**City of Portland, Maine - Building or Use Permit Application**  
 389 Congress Street, 04101 Tel: (207) 874-8703, Fax: (207) 874-8716

<b>Permit No:</b> 09-0948	<b>Issue Date:</b>	<b>CBL:</b> 036 E014001
------------------------------	--------------------	----------------------------

<b>Past Use:</b> 6 Unit Apartment Building	<b>Proposed Use:</b> 6 Unit Apartment Building rebuild 6' x 20'4" side egress stairs plus 7' to grade that serves 1 unit on the second floor.	<b>Permit Fee:</b> \$40.00	<b>Cost of Work:</b> \$1,500.00	<b>CEO District:</b> 2
<b>Proposed Project Description:</b> Rebuild 6' x 20'4" side egress stairs plus 7' to grade that serves 1 unit on the second floor.		<b>FIRE DEPT:</b> <input type="checkbox"/> Approved <input type="checkbox"/> Denied	<b>INSPECTION:</b> Use Group: Type	
		Signature:	Signature:	
<b>PEDESTRIAN ACTIVITIES DISTRICT (P.A.D.)</b>				
Action <input type="checkbox"/> Approved <input type="checkbox"/> Approved w/Condition <input type="checkbox"/> Denied				
		Signature:	Date:

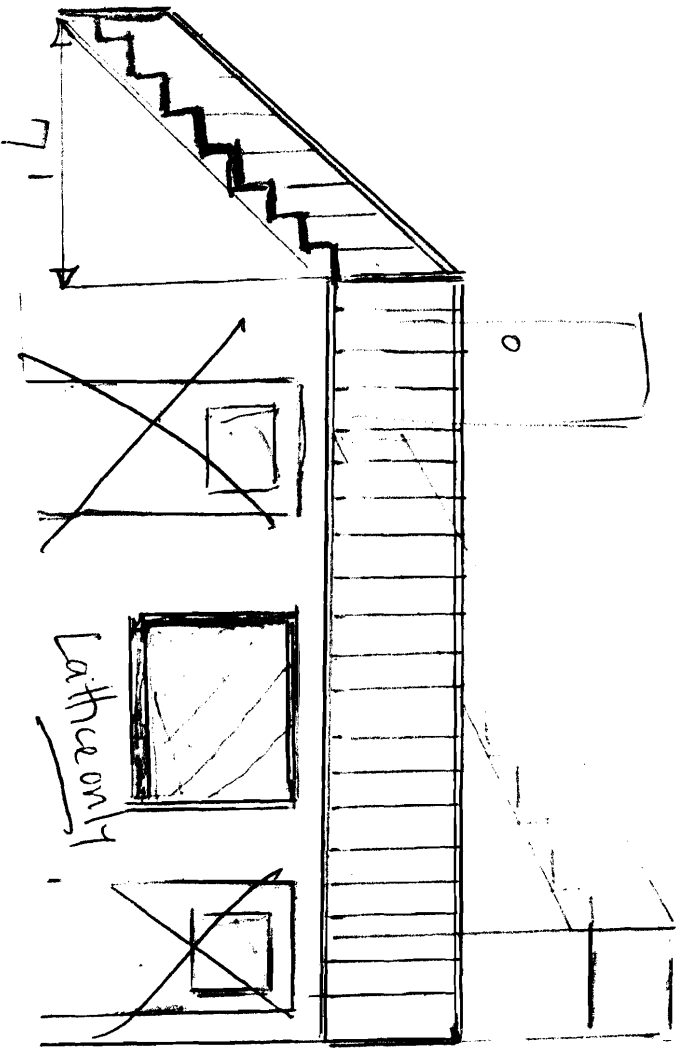
<p>1) This approves the egress deck and stairs only, enclosed storage access is not allowed below/under these stairs/deck as designed, it can be enclosed with lattice skirting.</p> <p>2) Permit approved based on the plans submitted and reviewed w/owner/contractor, with additional information as agreed on and as noted on plans.</p>

9/1/2009-jmb: Spoke to Marie as the enclosed storage area beneath the stair is not allowed unless fire rated sheetrock is installed. Since this would require the room to be weather tight they will enclose with access, only skirt with lattice. She and Tad the contractor came in to discuss the details as noted on the plans. The design is contingent on the constraints of the existing building dimensions and the 1st floor egress door.

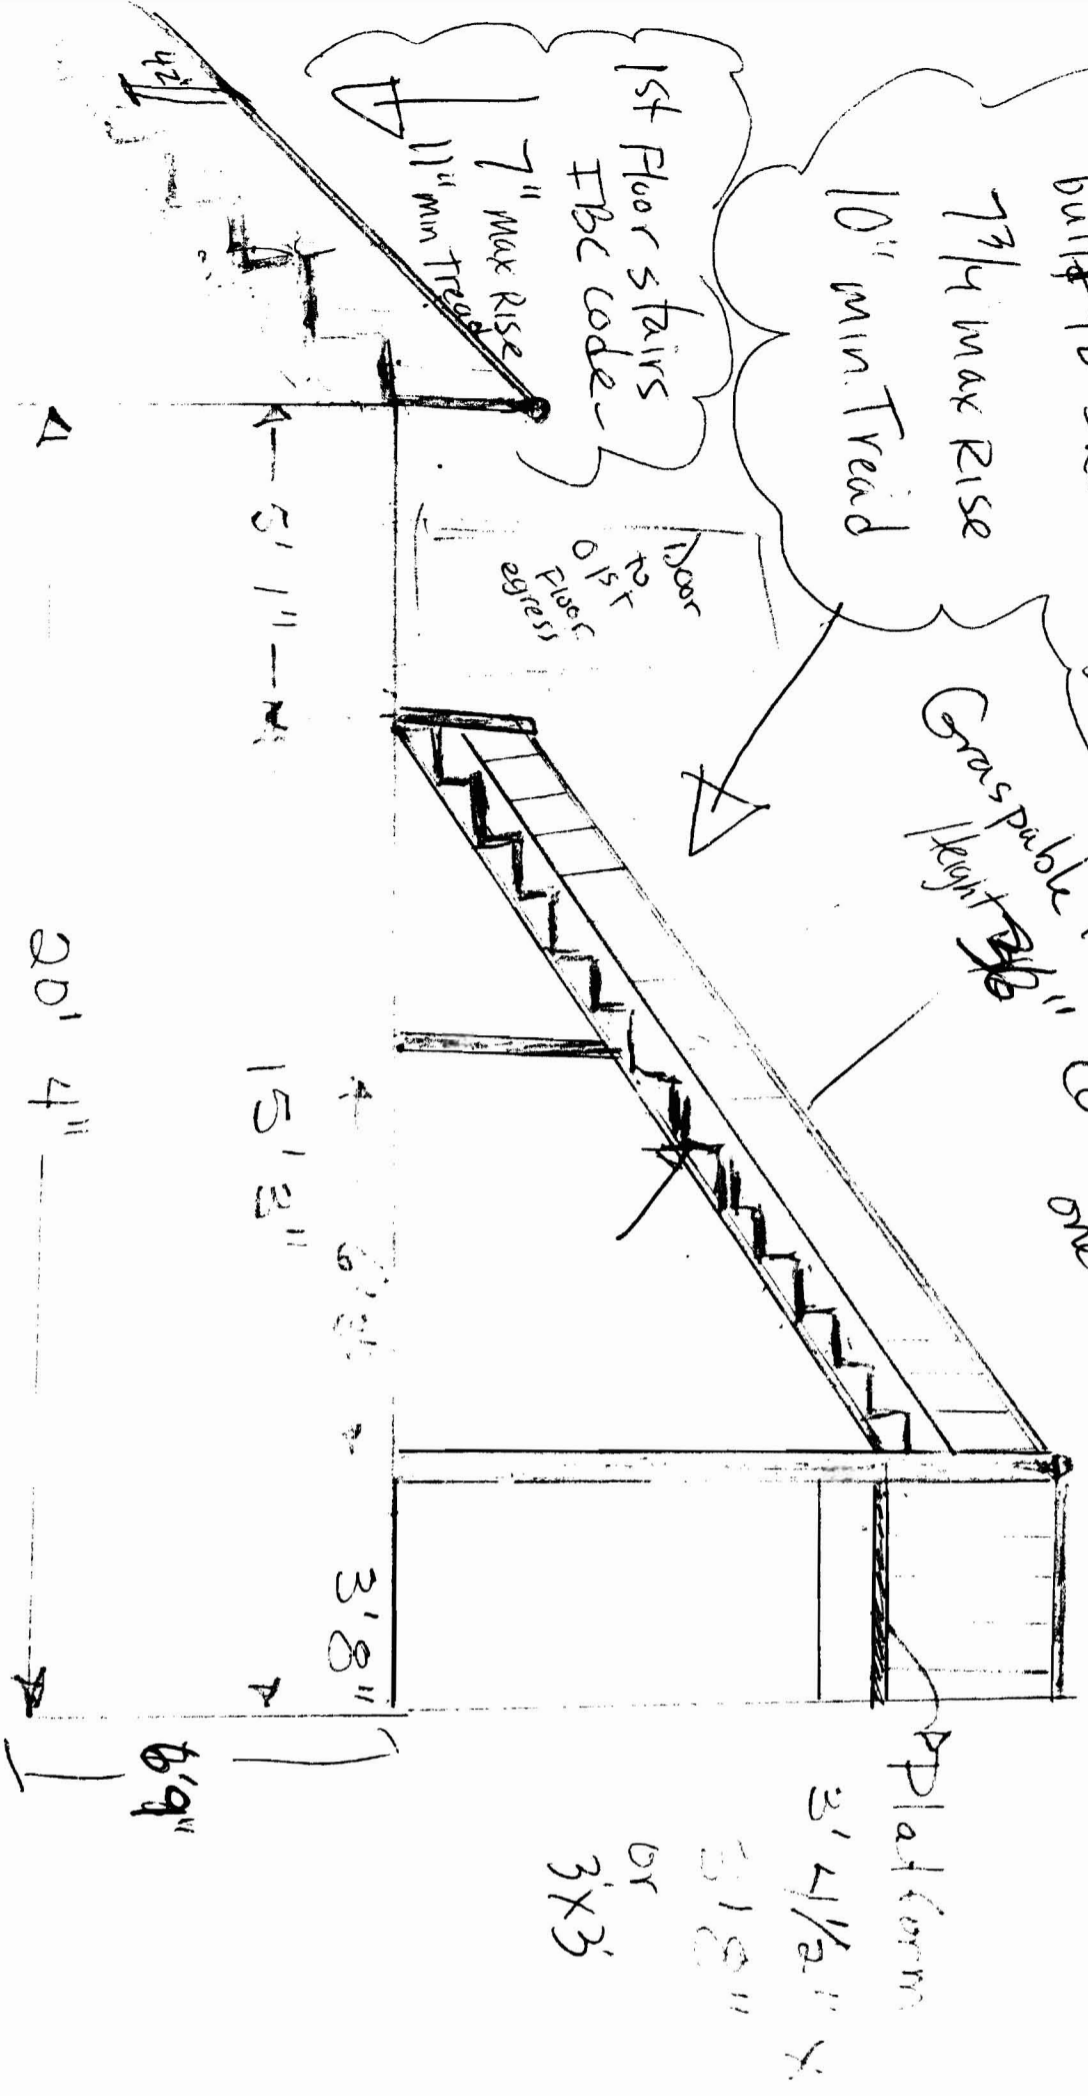
8/31/2009-jmb: Marie came in for a permit by appointment due to this being an egress in disrepair and only serving 1 unit of the 6. She will submit the details on the beam size, footing spacing and framing design.
